Department of Transportation

January 24, 2020

RE: Pearson's Ministries - dba Legacy Church - Hydraulics and Site Development
Plan_PPR1933

REV: 11/22/19
REV: 10/18/19
PROPOSED DRAINAGE PLAN
SHEET 2 OF 3

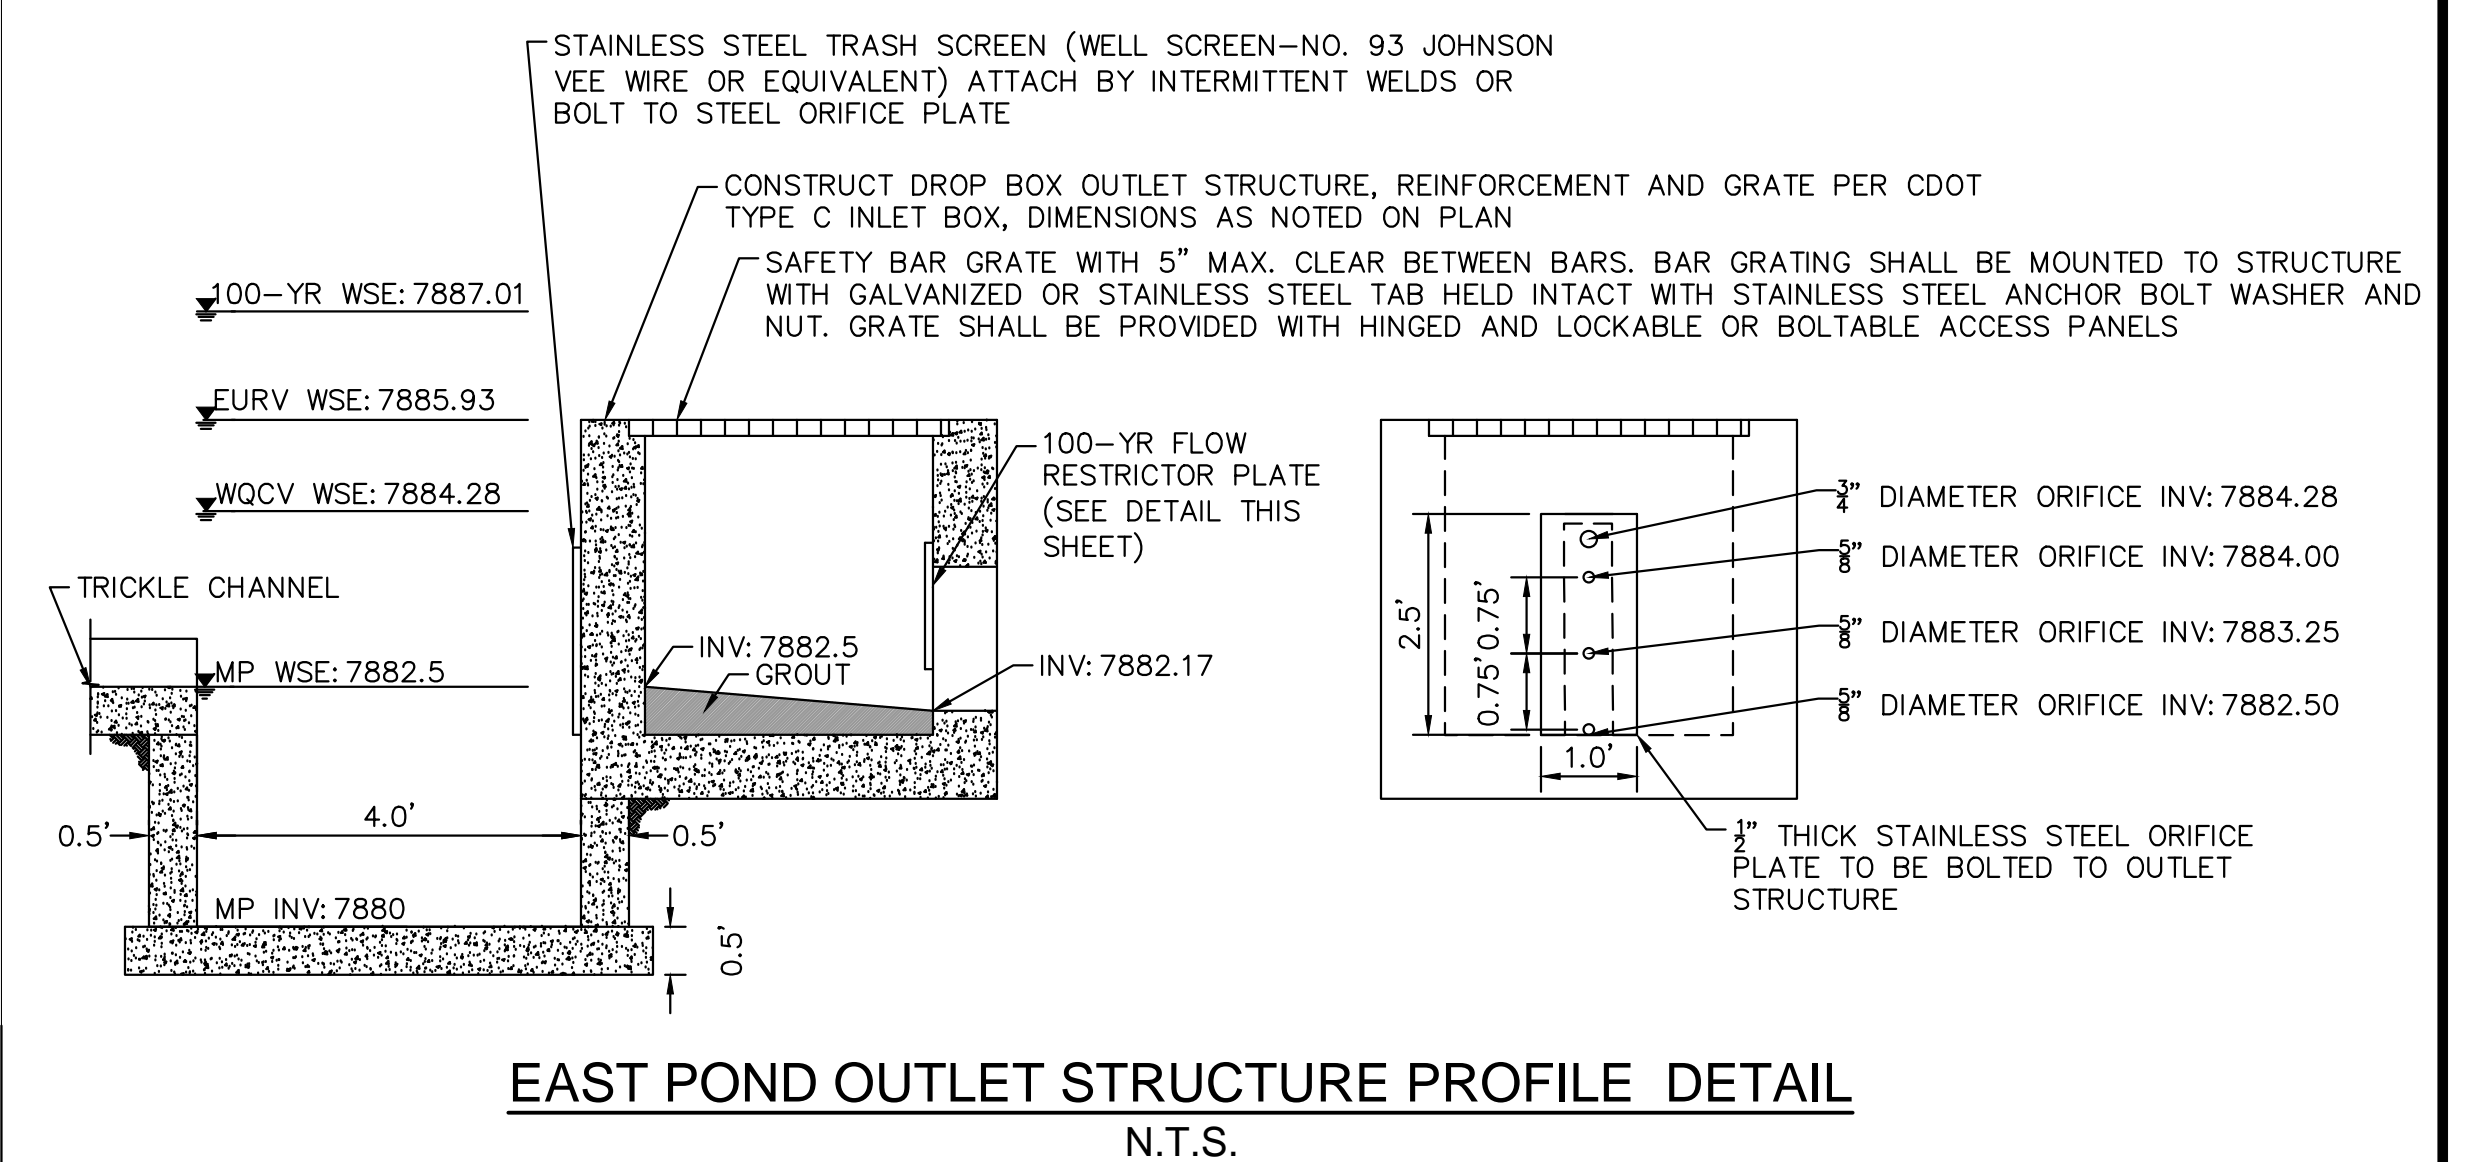
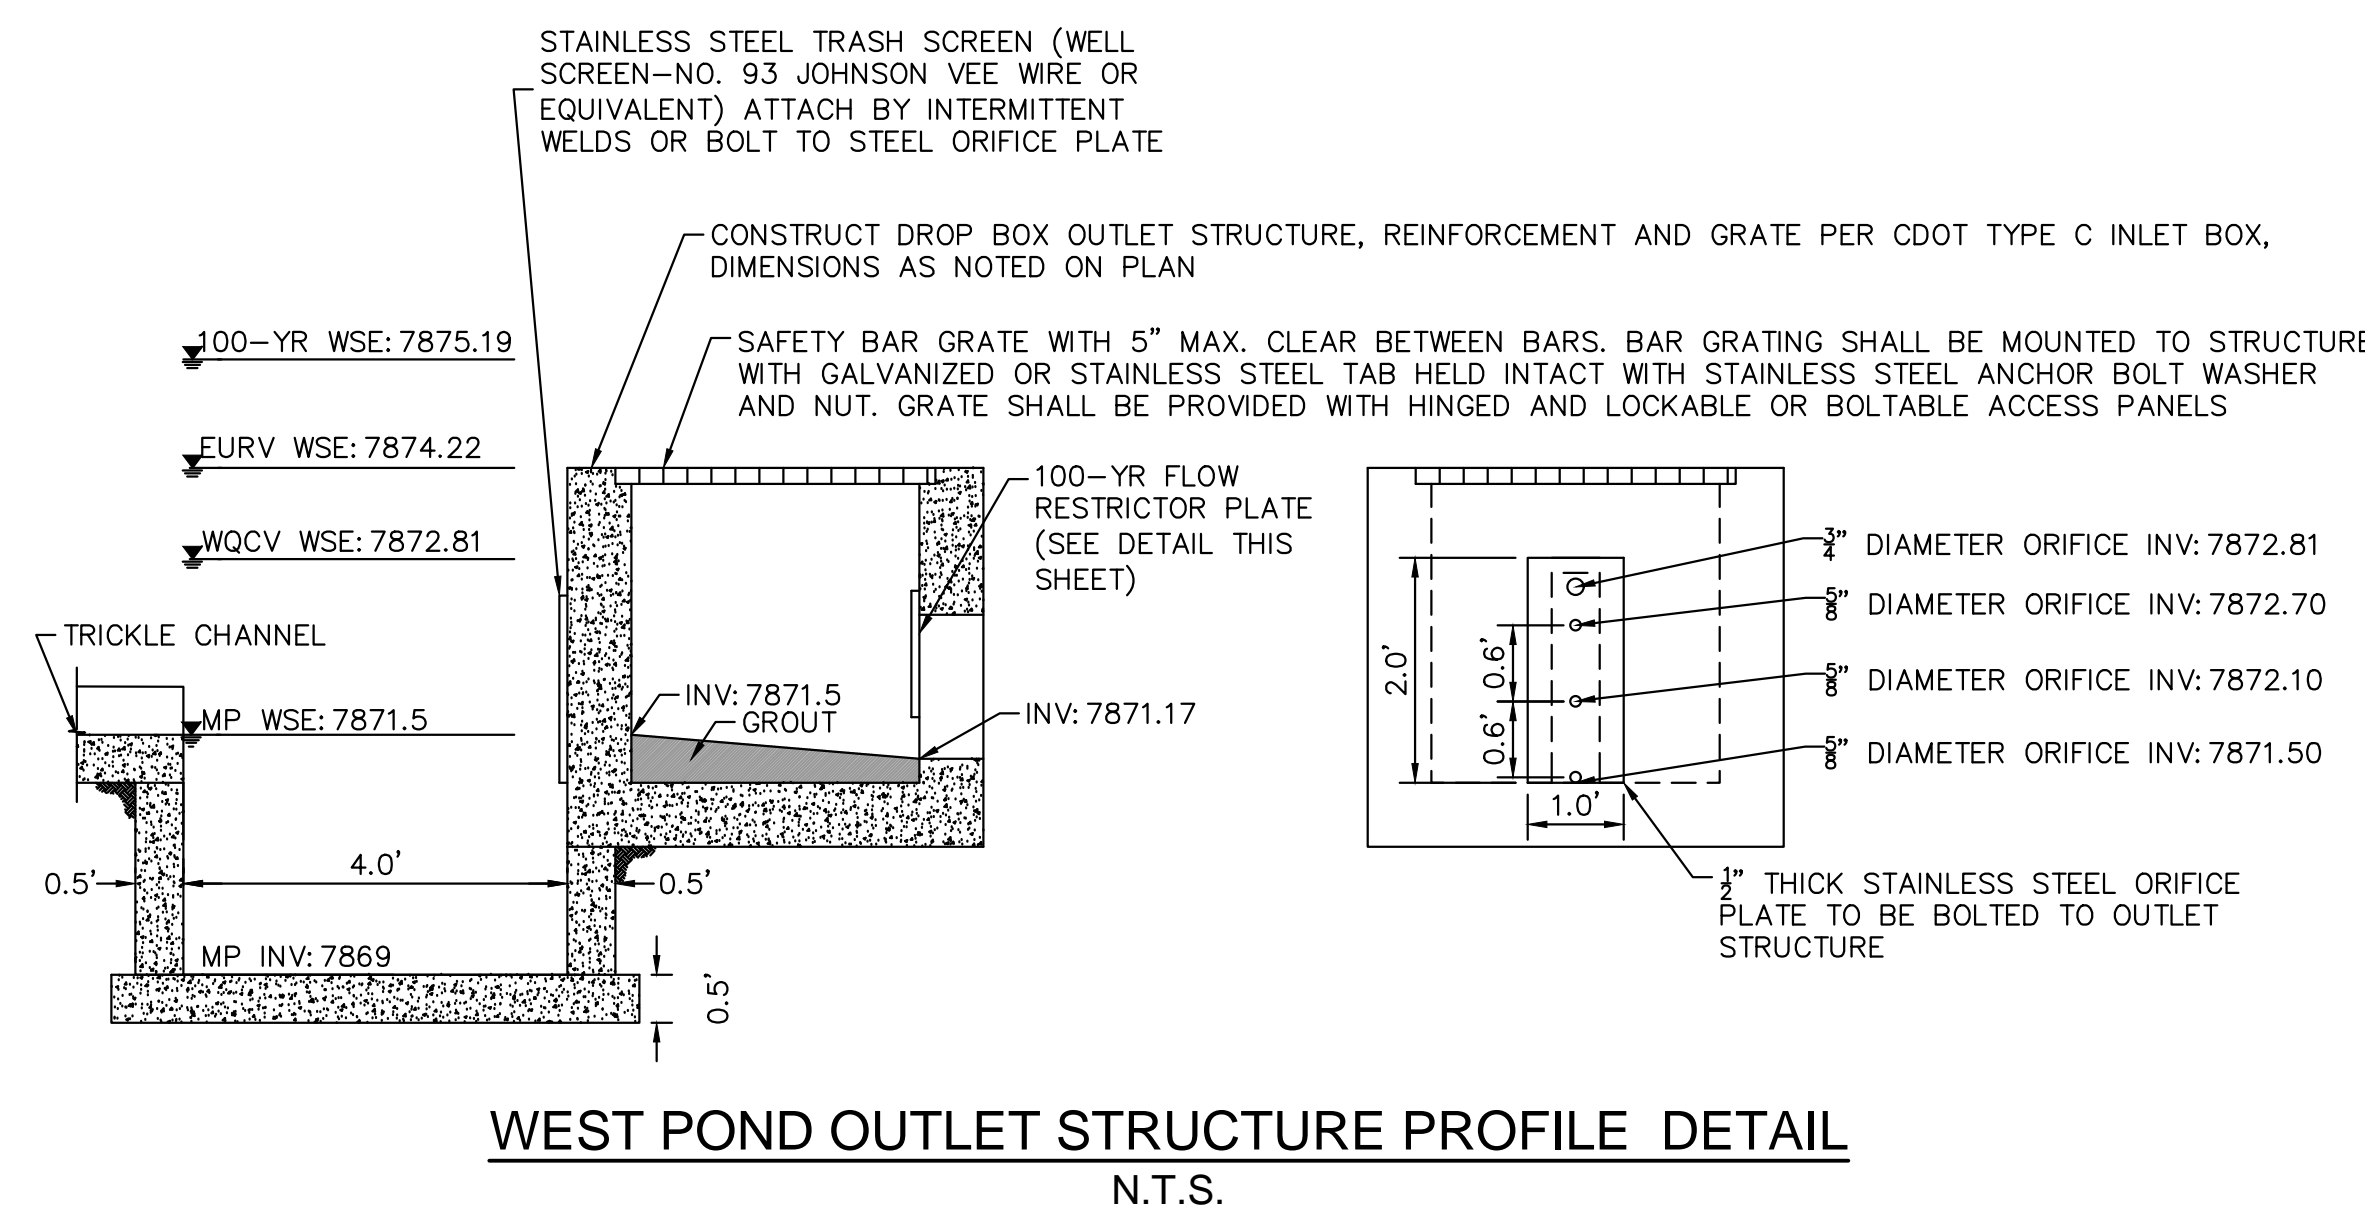
- c. Existing 24" pipe draining to the southwest is shown connecting to a pipe that appears to be proposed by this project, sheet 4. Details are missing, please provide.

- d. Riprap rundown shown at the outlet of the proposed pipe run C01. Need to see construction details and calculations that show the proposed riprap design is adequate. Drainage report mentions that this is a concrete rundown. Which is it? Need to ensure that it extends to the bottom of the CDOT ditch and up the ditch back slope to ensure the ditch is not eroded.

- l. A culvert and ditch were added southeast of the east detention basin. This ditch outfall onto the church access road. This concentrated flow outfall condition will cause erosion along the edge of the proposed drive and likely undermine the pavement as well as cause icing issues in winter. Please provide a way for this water to drain either in a ditch along the access road or another culvert under the access road to prevent erosion.

LEGACY CHURCH
 GREEN MOUNTAIN FALLS, COLORADO
 GRADING AND EROSION CONTROL PLANS
 GRADING AND EROSION CONTROL PLAN

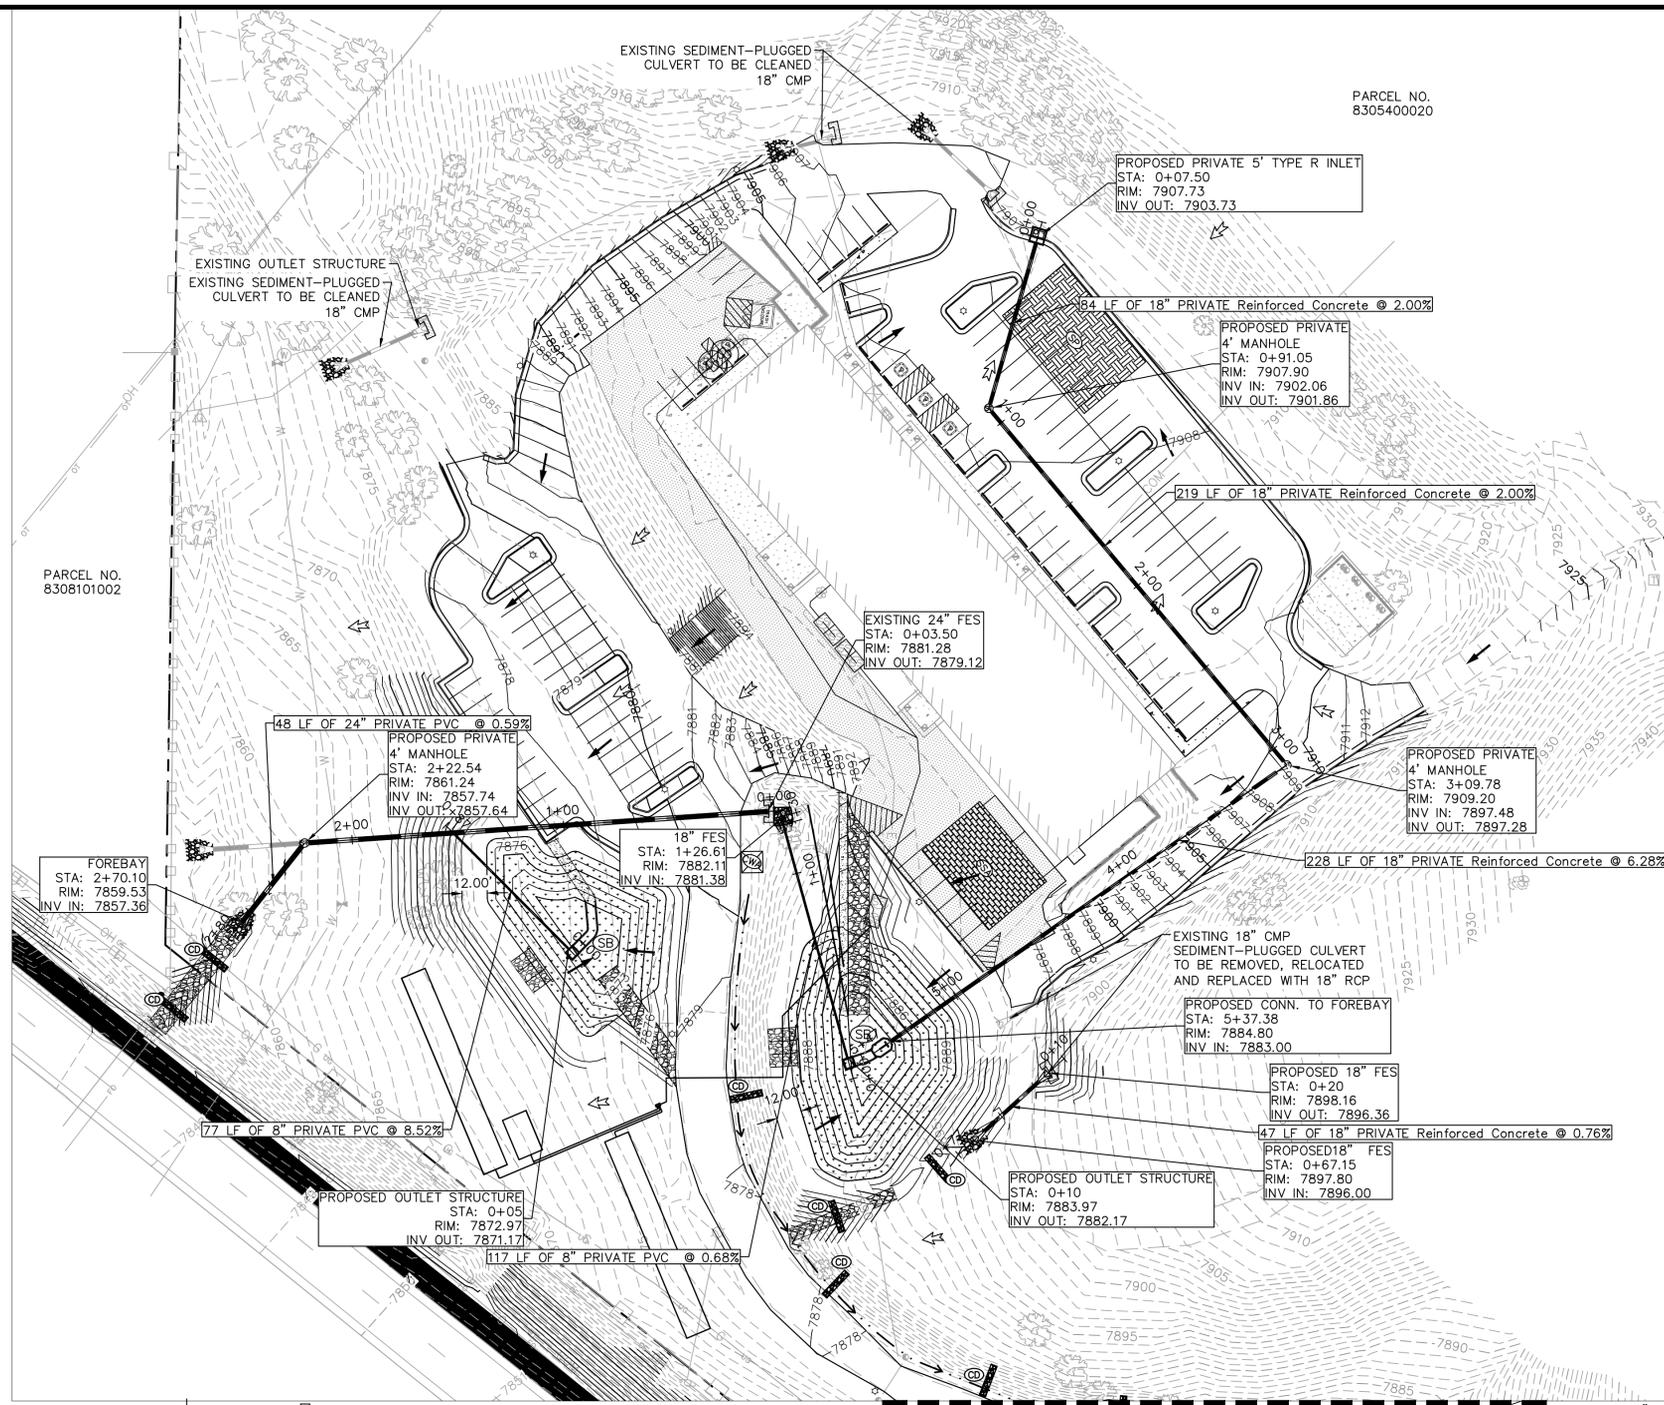
- e. Need plans for construction site BMPs so that CDOT ROW is not inundated with sediment from the construction project site. Significant grading on the project has high potential of erosion.

- m. Provide silt fence between proposed septic system and property line to ensure no

- n. Provide check dams perpendicular to flow within all rundowns and ditches along both sides of the access.
